**ADC Planning Consultation
Response from the Conservation Officer**

Application Number	AB/130/13
Address	Arden Guest House 4 Queens Lane Arundel BN18 9JN
Description	Change of use and extension to create 3no. self-contained apartments and 1no. maisonette. This application affects the character and appearance of Arundel Conservation Area
Case Officer	Mrs. A Gardner

Job Title	Arden Guest House	
Client	Mr & Mrs Meathrel	
Drawing Name	Proposed Ground Floor Plan	
Drawing Status	Planning	
Drawn by	DF	Date Dec 13
Checked by		Date
Drawing Scale	1:50 at A2	
Drawing No	Status	Revision
13519/ 05

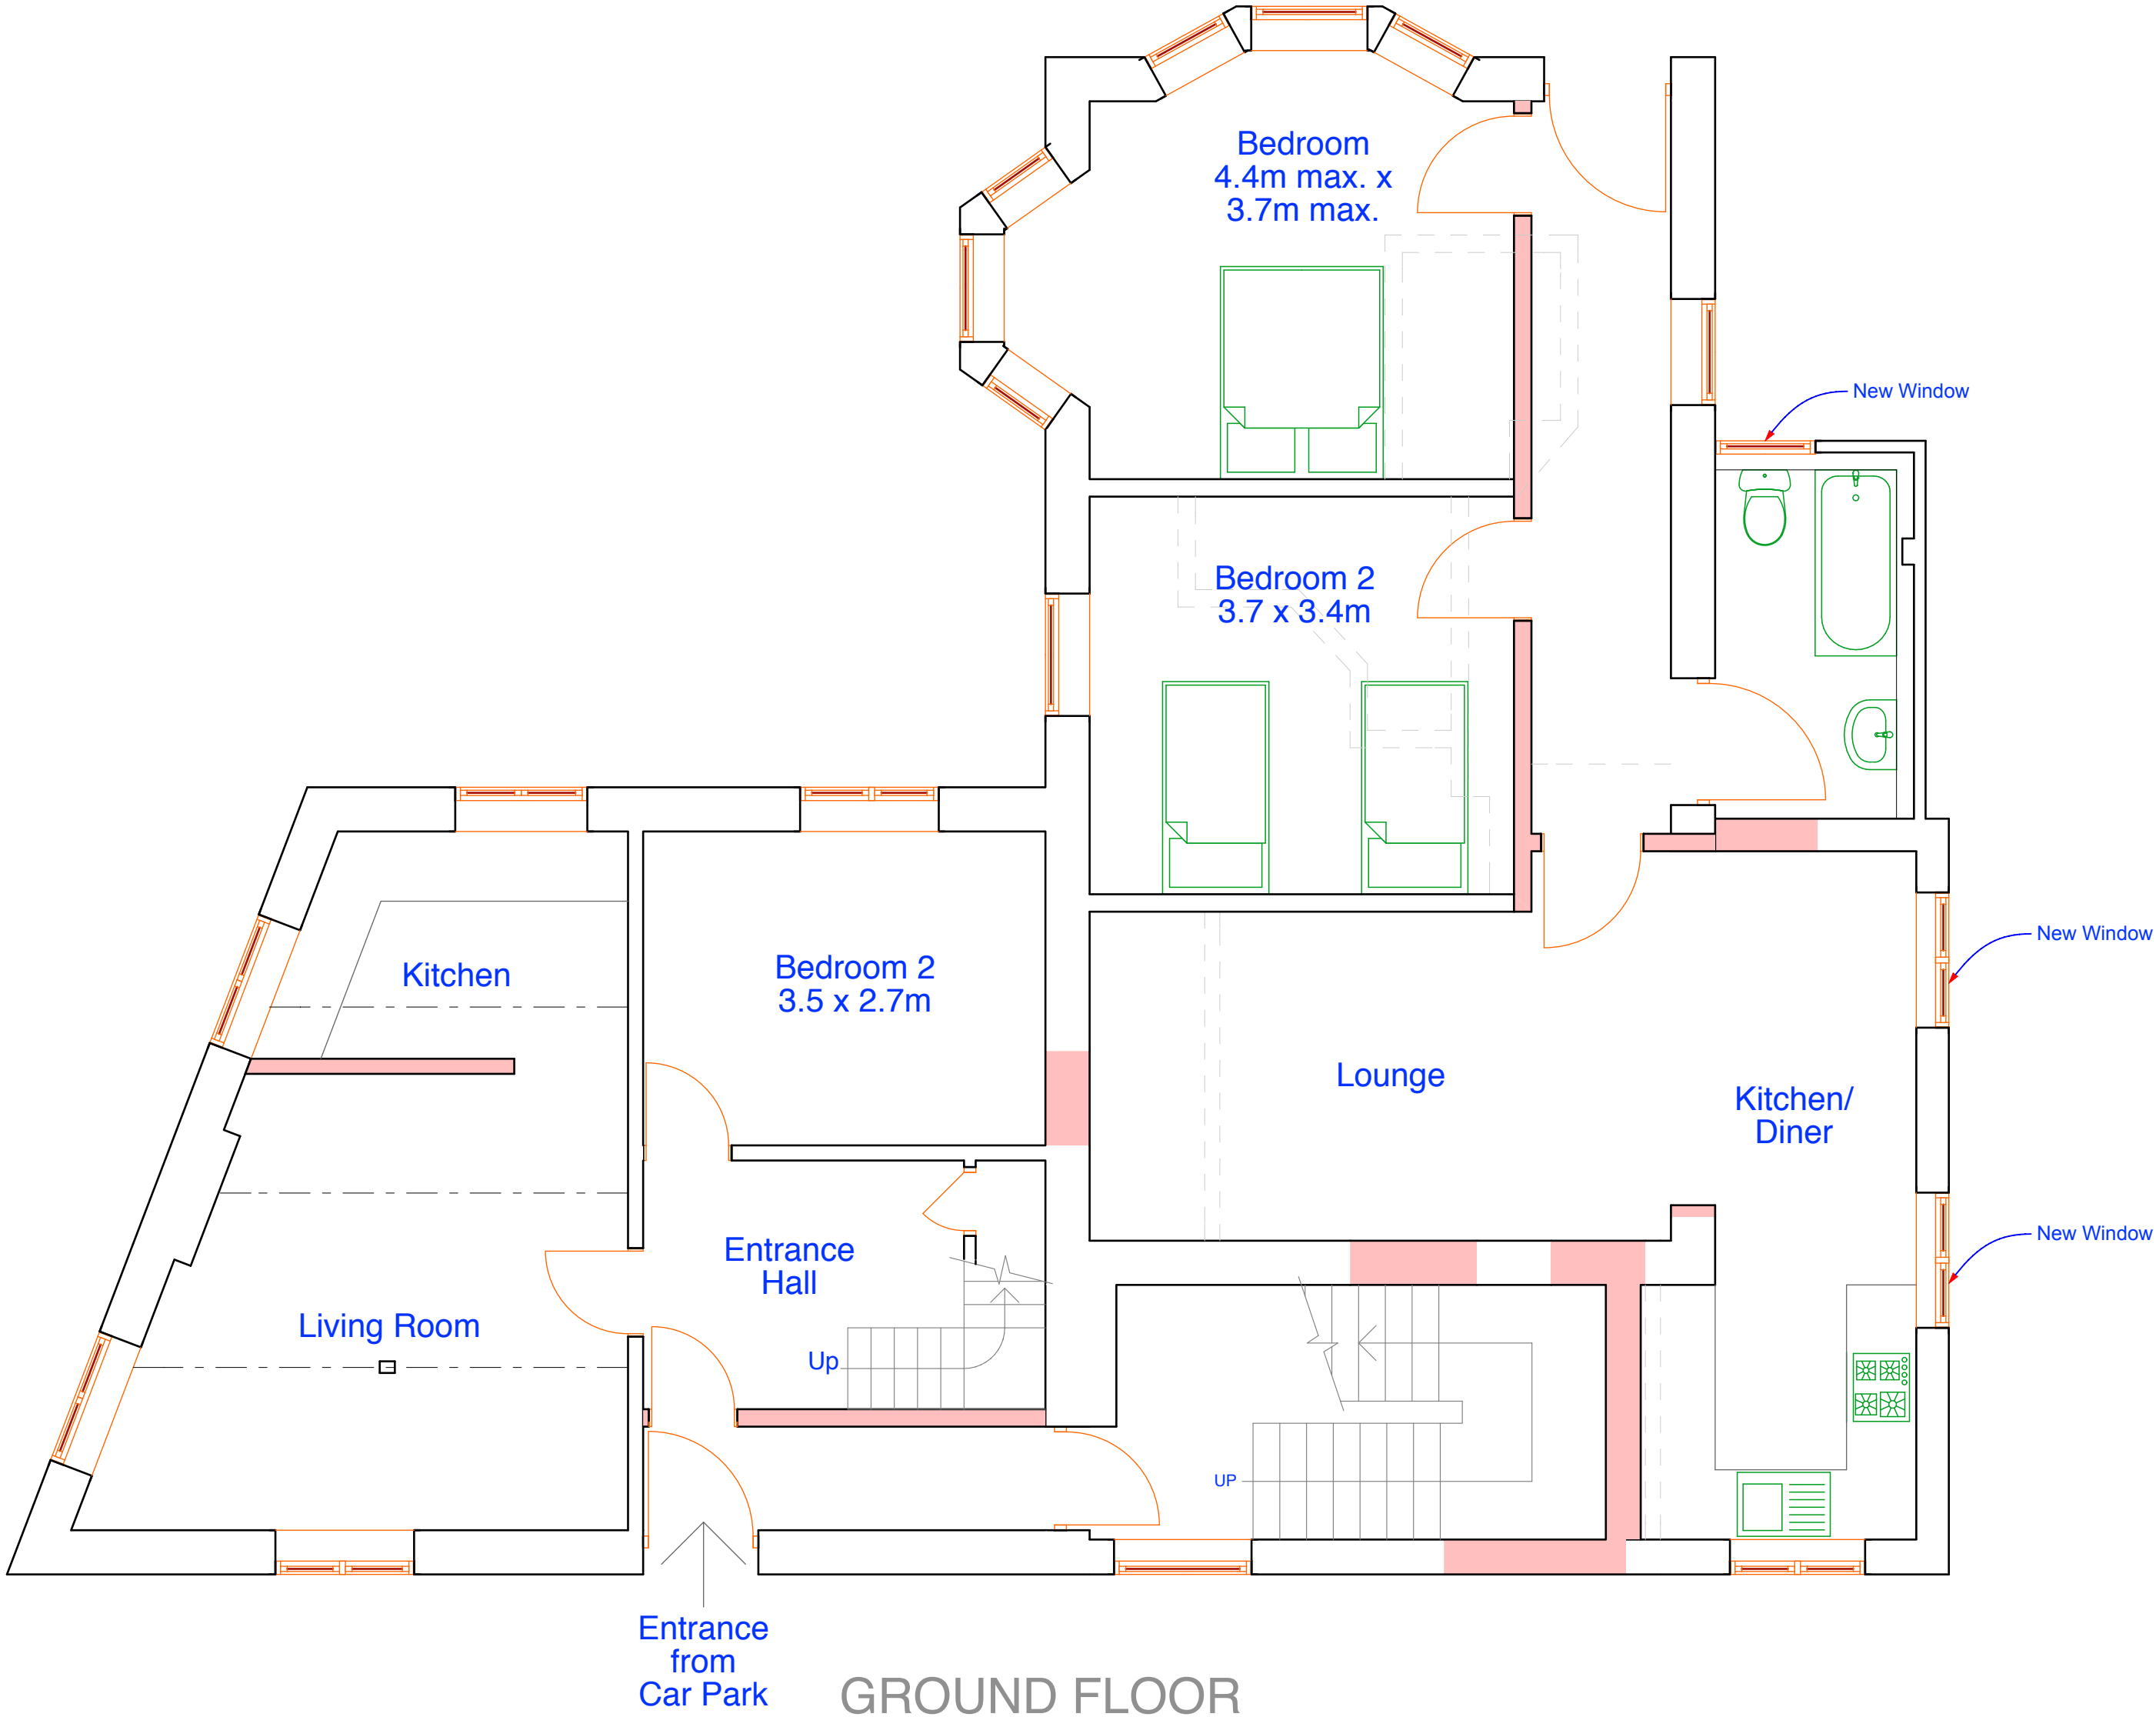
As the property is located on a corner, the proposed parking has the potential to have a significant impact upon the street-scene. This is especially true of the parking space for flat number 2. It is suggested that an alternative location be sought for this space. This will then enable some amenity space to be provided which will have a positive impact on the street-scene.

Job Title	Arden Guest House		
Client	Mr & Mrs Meathrel		
Drawing Name	Proposed Elevations		
Drawing Status	Planning		
Drawn by	DF	Date	Dec 13
Checked by		Date	
Drawing Scale	1:100 at A2		
Drawing No	Status	Revision	
13519/	08

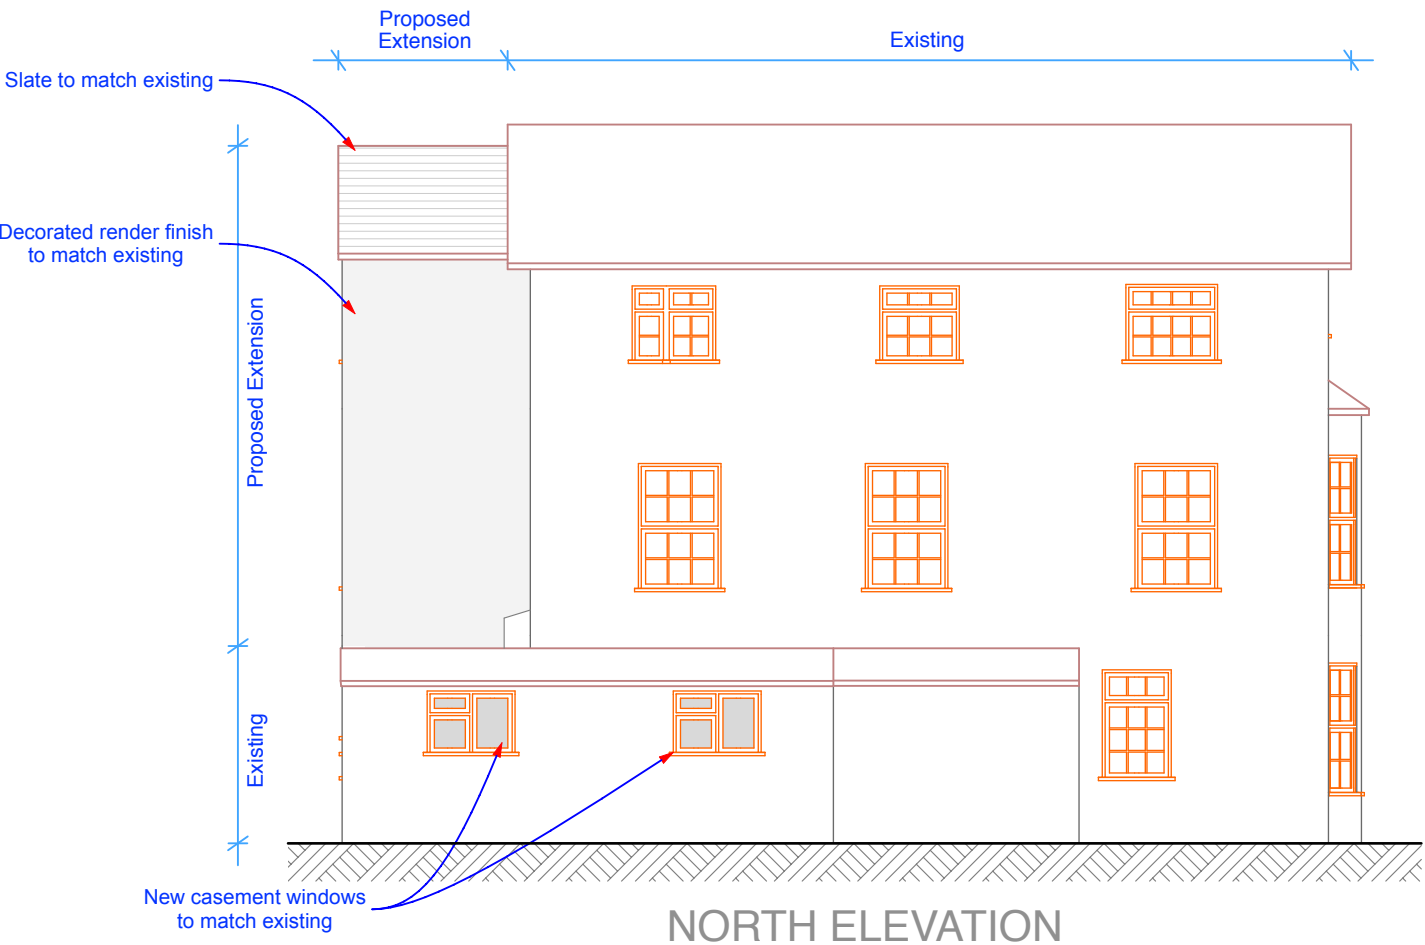
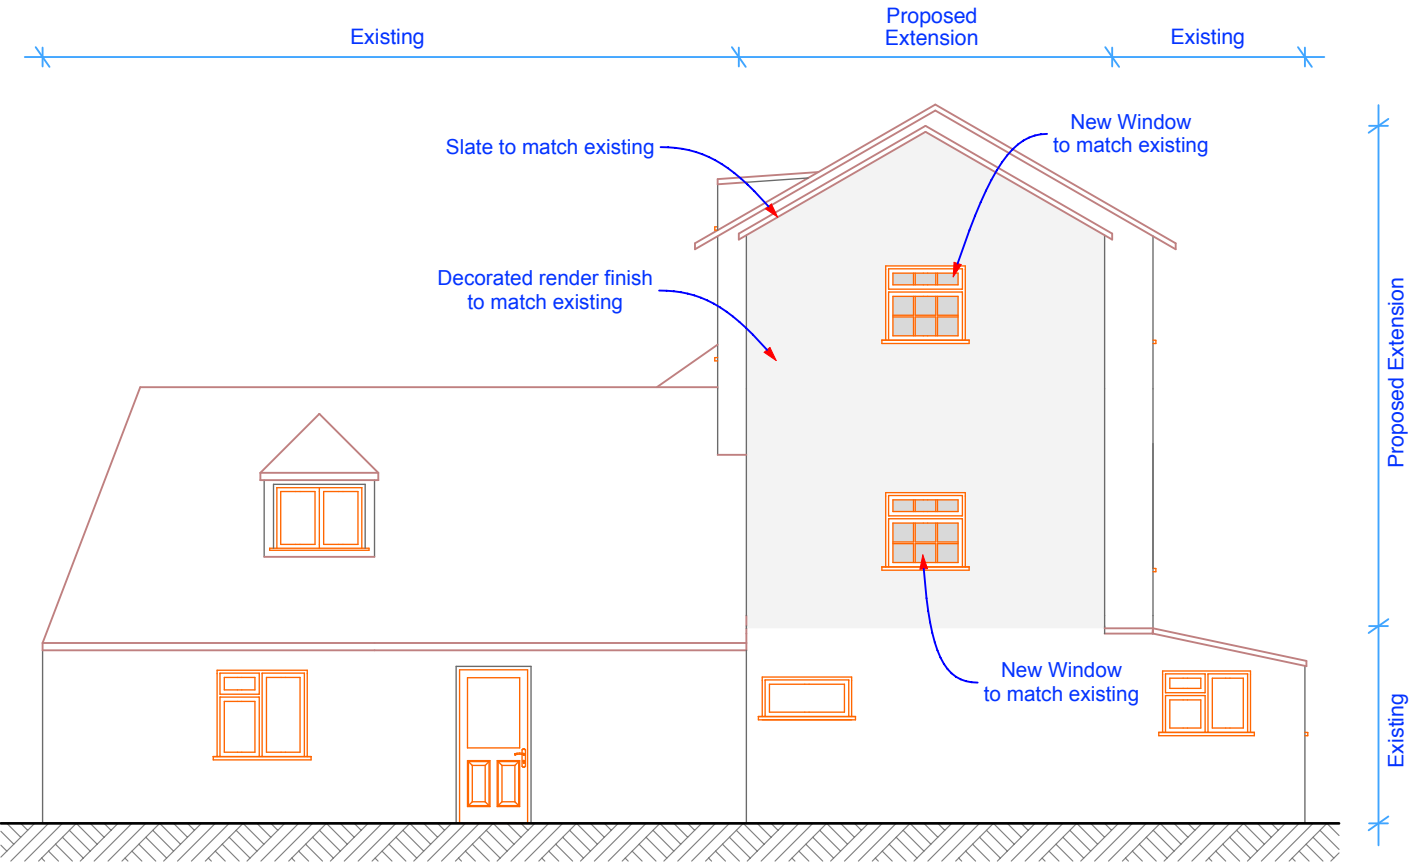
It is considered that any new windows and doors should replicate existing whilst also being appropriate for the conservation area. For example, I am thinking of the new casement windows in the ground floor of the northern elevation. As it currently stands, these appear to be standard, off the shelf windows which do not enhance the building or the locality.
